Royal Prince Alfred Hospital North West Precinct Redevelopment

PREFERRED PROJECT REPORT

Architectural Design Statement

Document Reference: 3599-0603-011

**LOWER GROUND LEVEL PLAN**

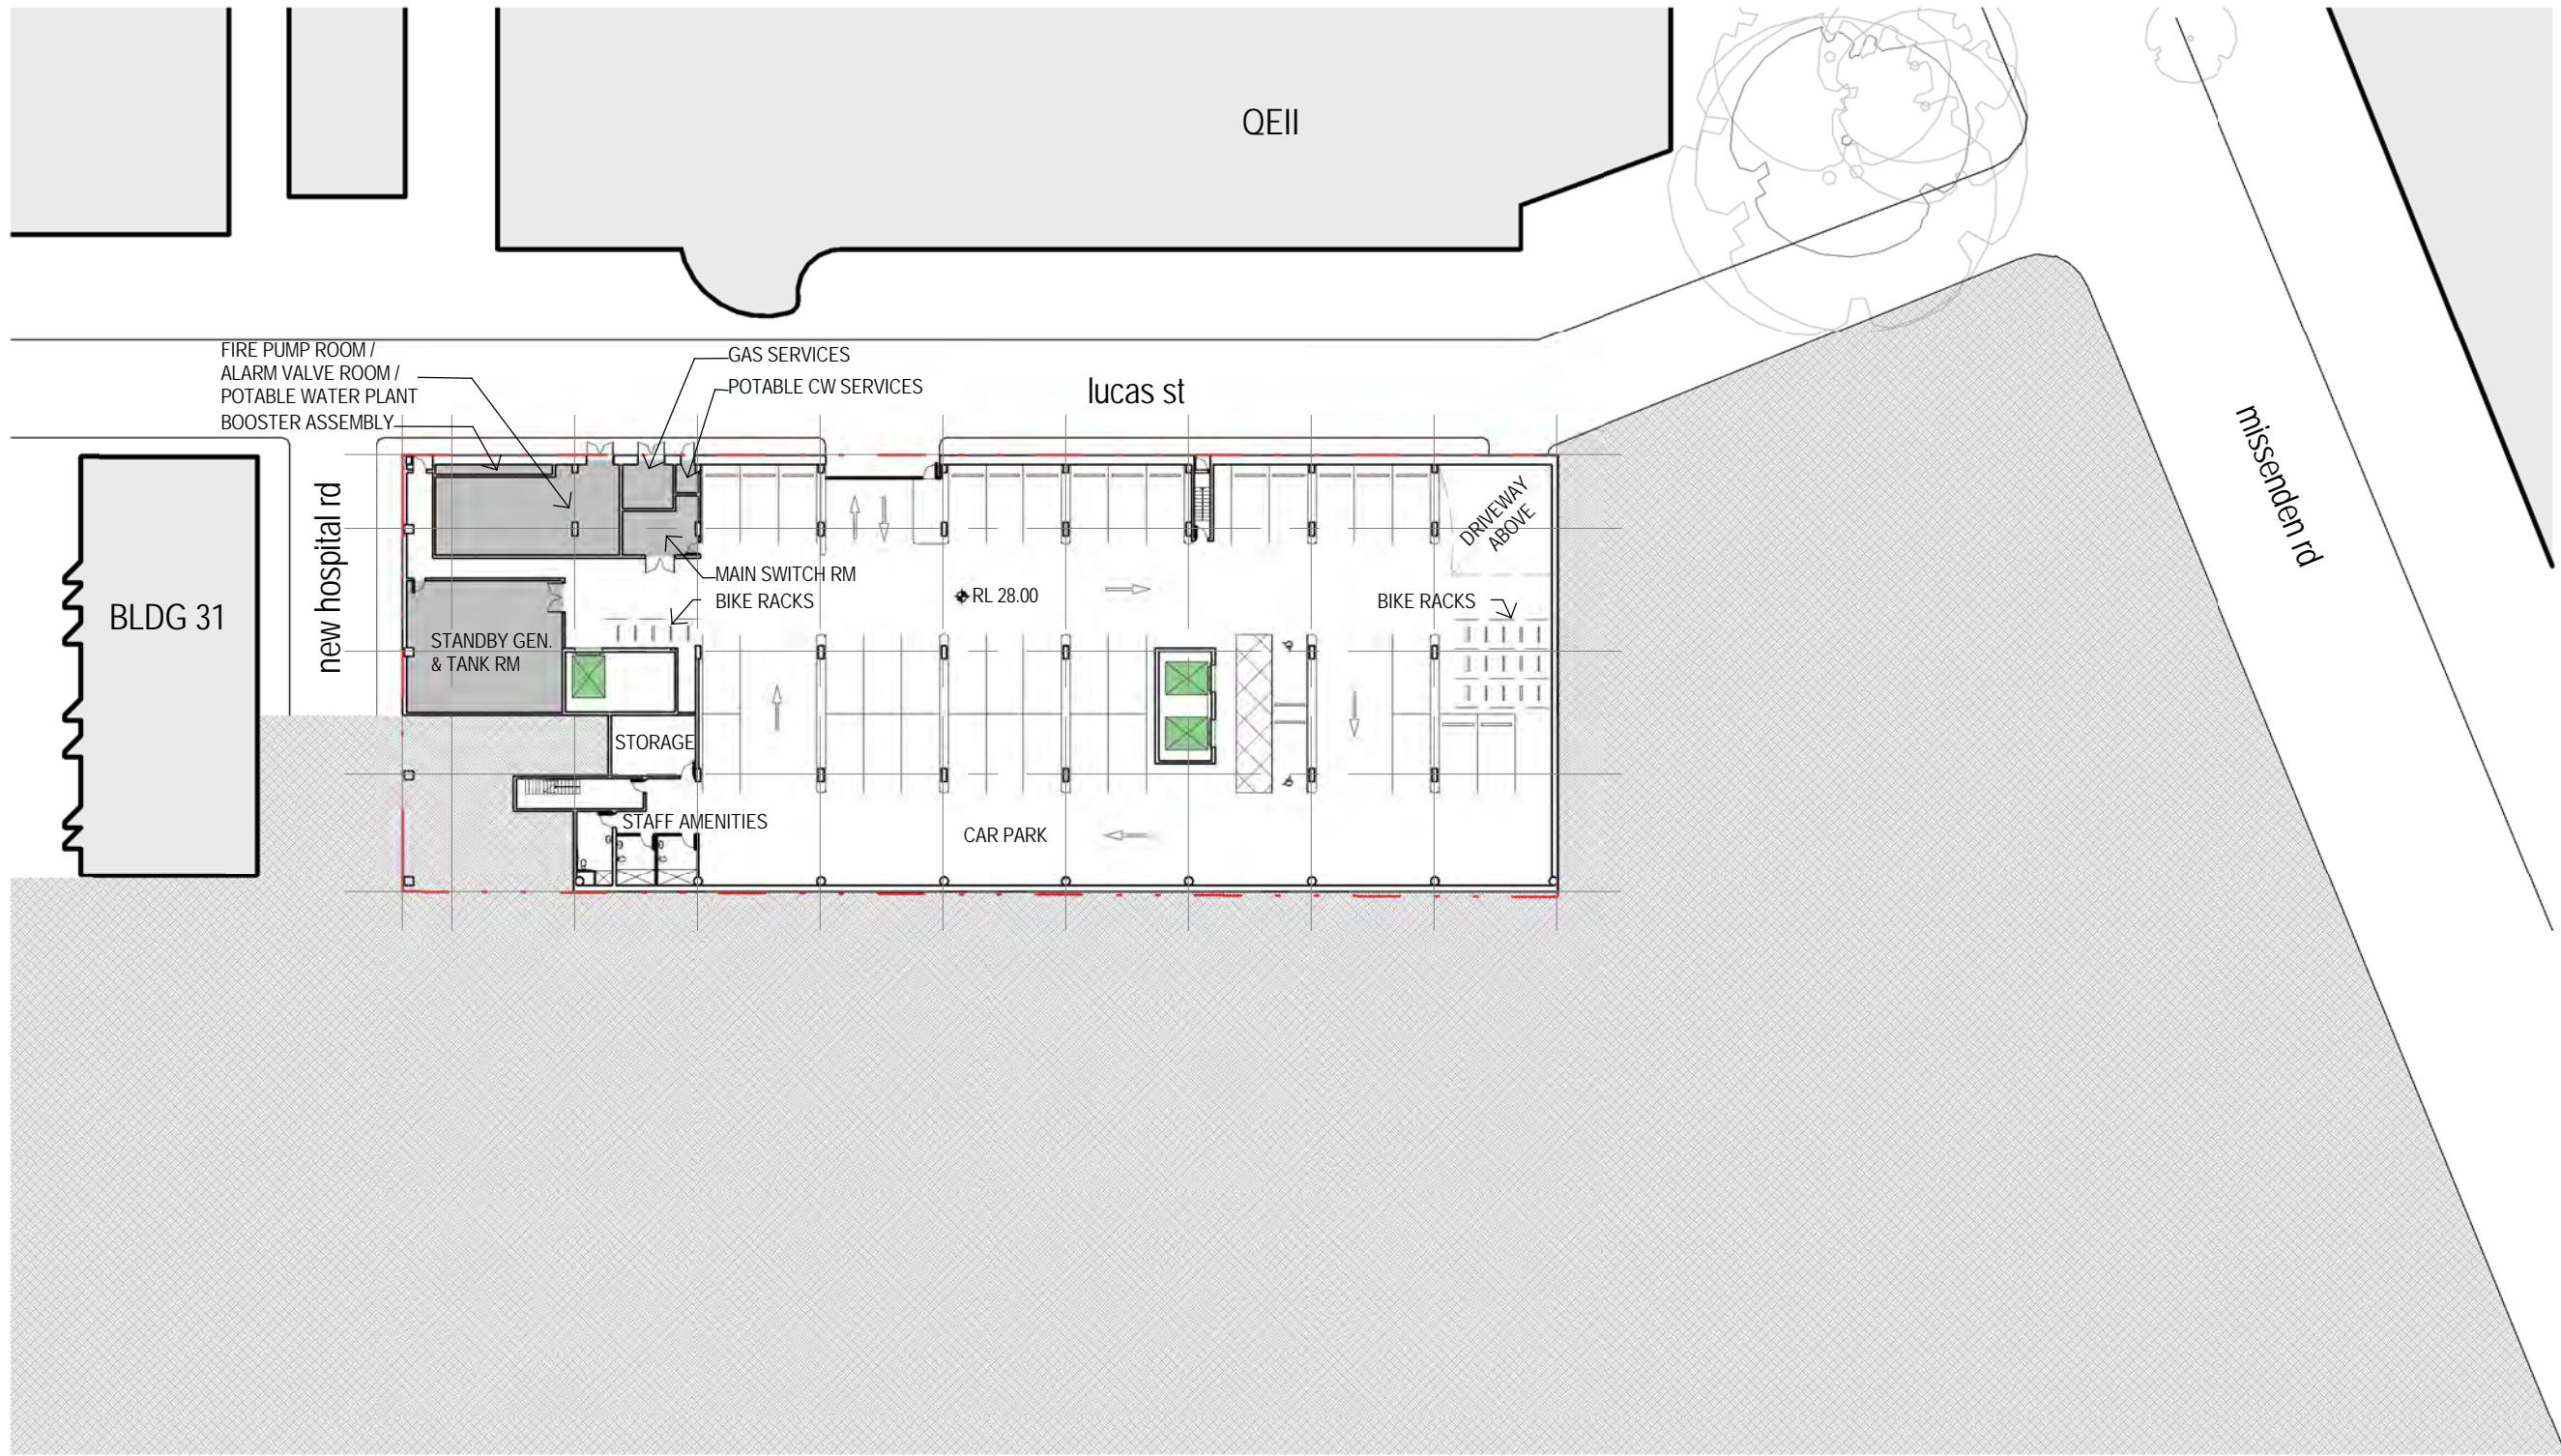
- General configurations and extent of building services;
- Configuration of the vehicle entry into the car park to incorporate boom gates and roller shutter; and
- Egress doors, access stairs and ramps have been setout to ensure that these elements do not encroach on the public domain.

**GROUND LEVEL PLAN**

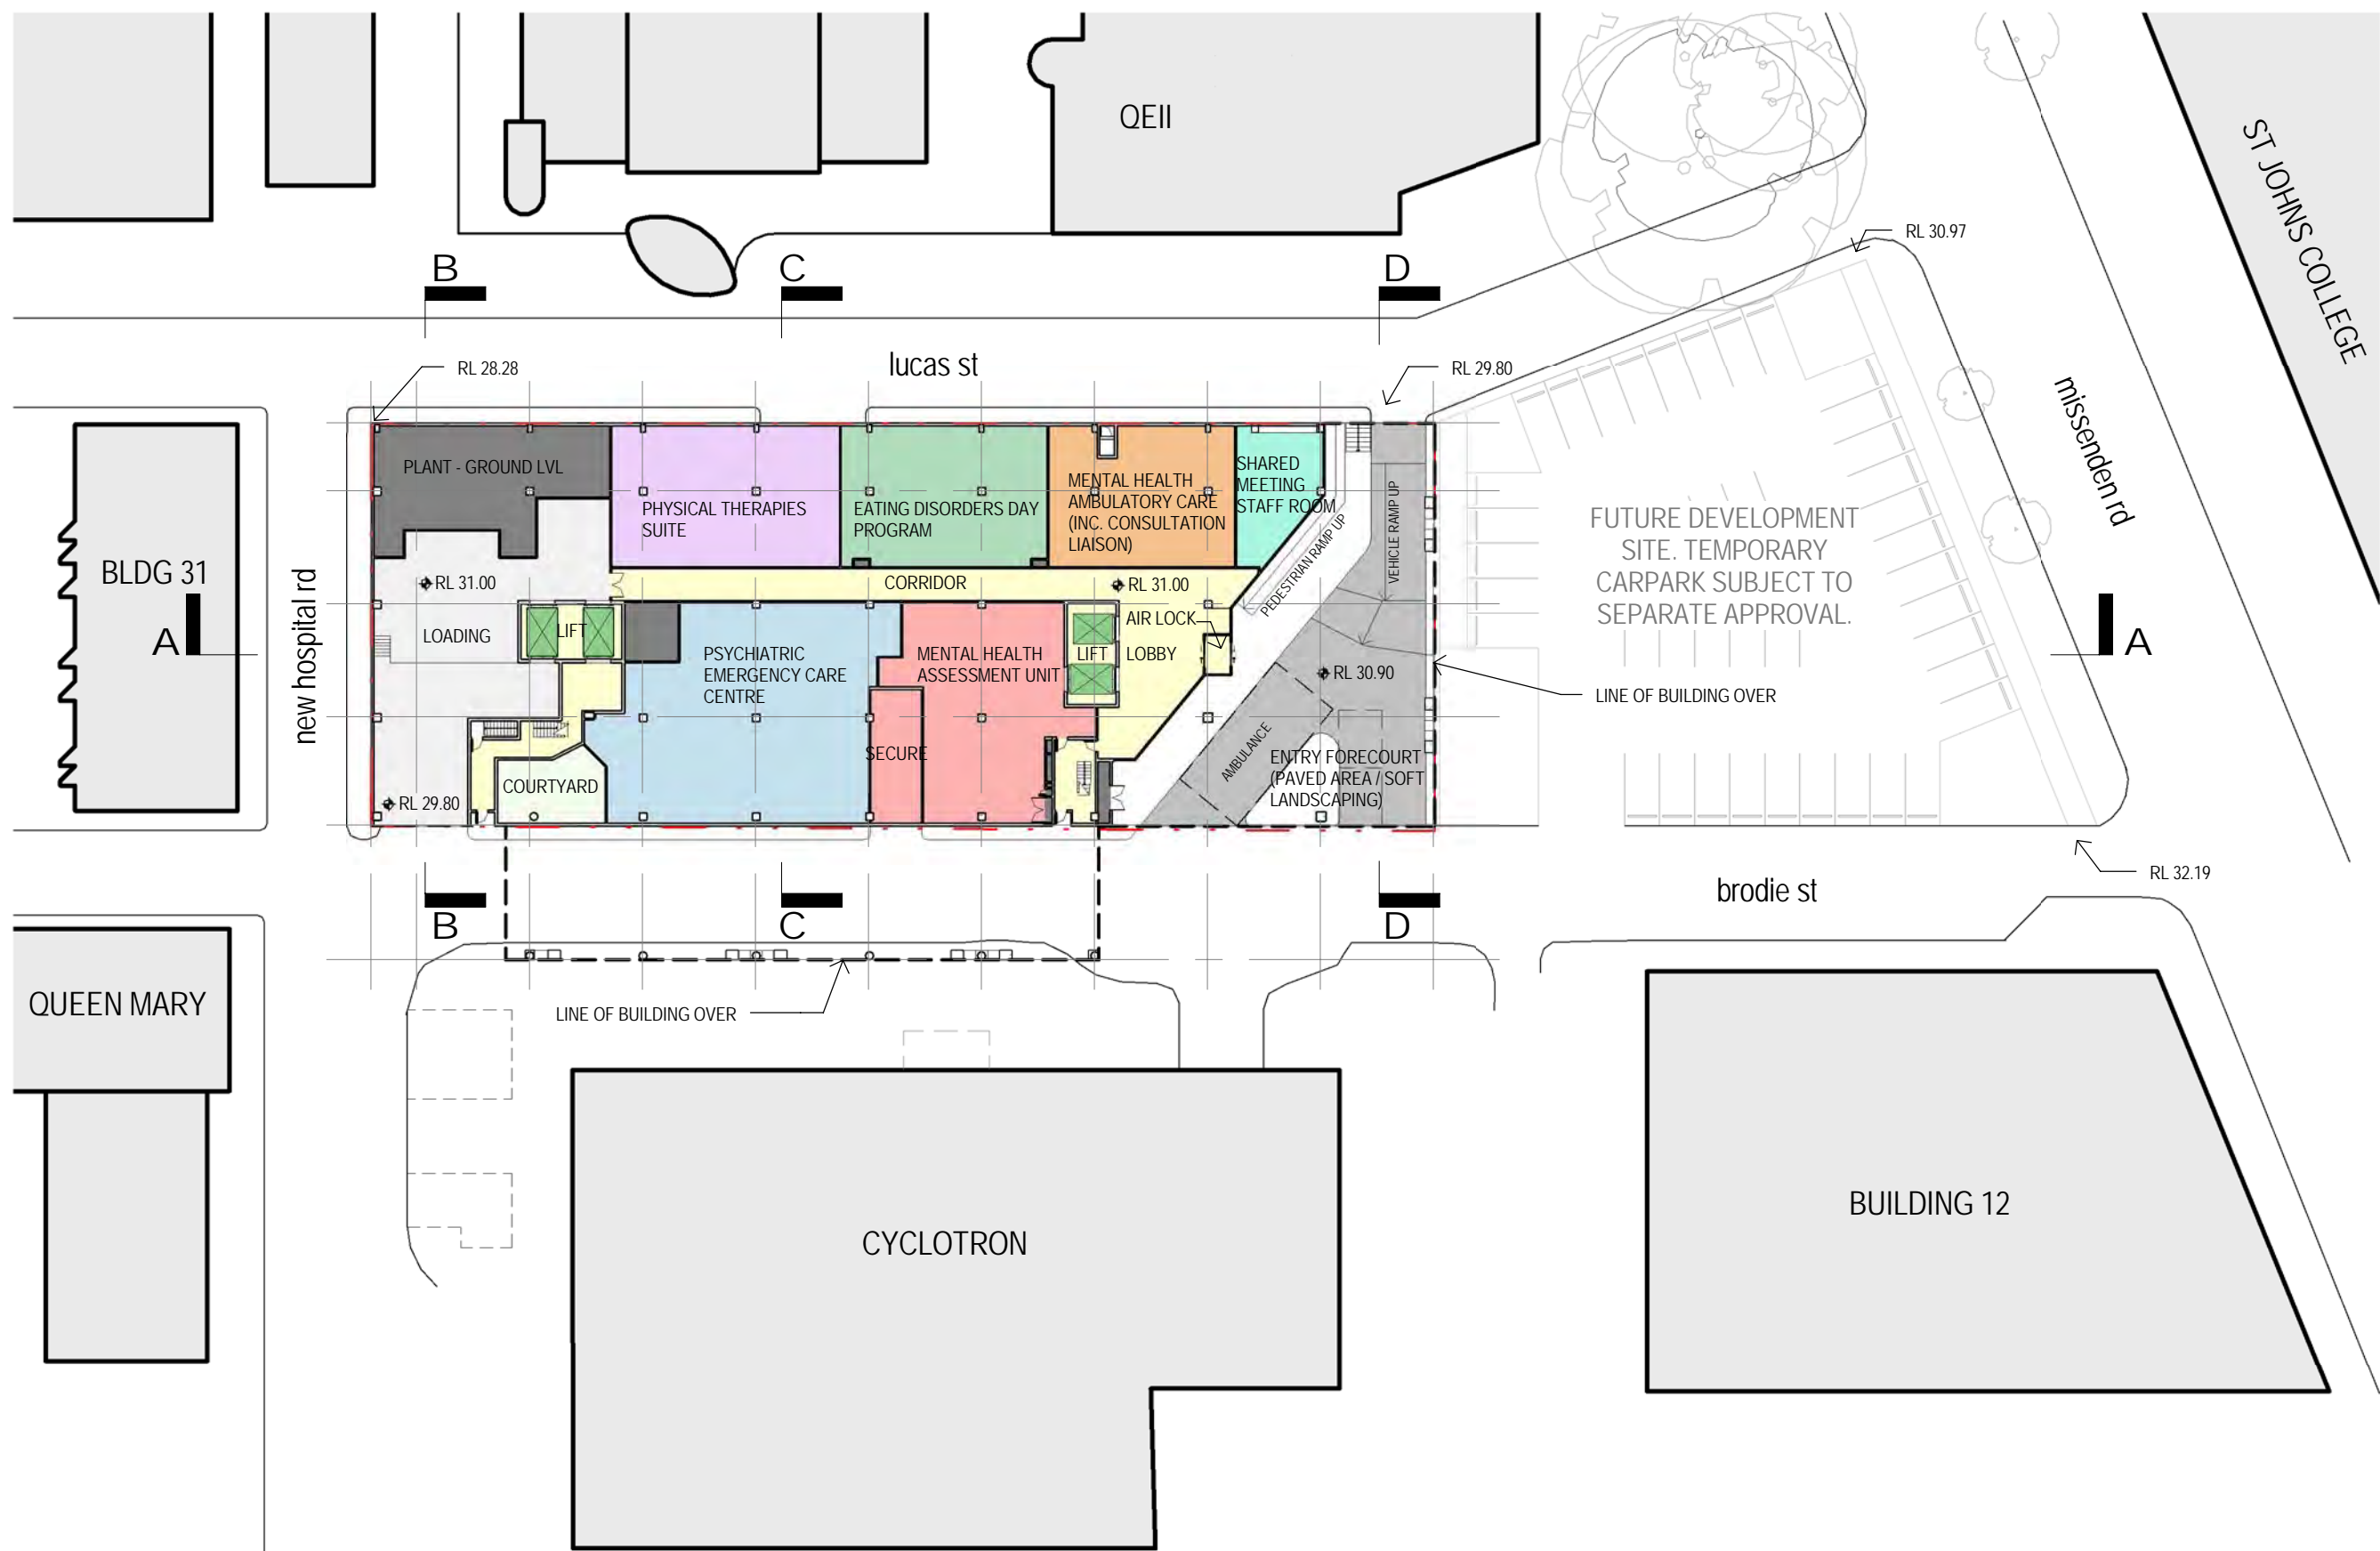
- Positioning of new secondary building entry off Lucas Street which provides a setback to ensure visual prominence;
- Focusing the pedestrian entry towards Brodie Street which provides the most direct link to the main car park and main campus on Missenden Road;
- Providing a dedicated vehicular drop off area that is independent and separate to the pedestrian entry;

- Improved activation and transparency within the cantilevered section over Brodie Street;
- Psychiatric Emergency Care Centre is now called Short Stay Unit;
- The secure parking area that is associated with the Mental Health Assessment Unit has been relocated in order to accommodate the functional requirements of the Mental Health Assessment Unit; and
- Ramp access is provided to the Mental Health Assessment to achieve statutory compliance and negotiate the change in site levels.
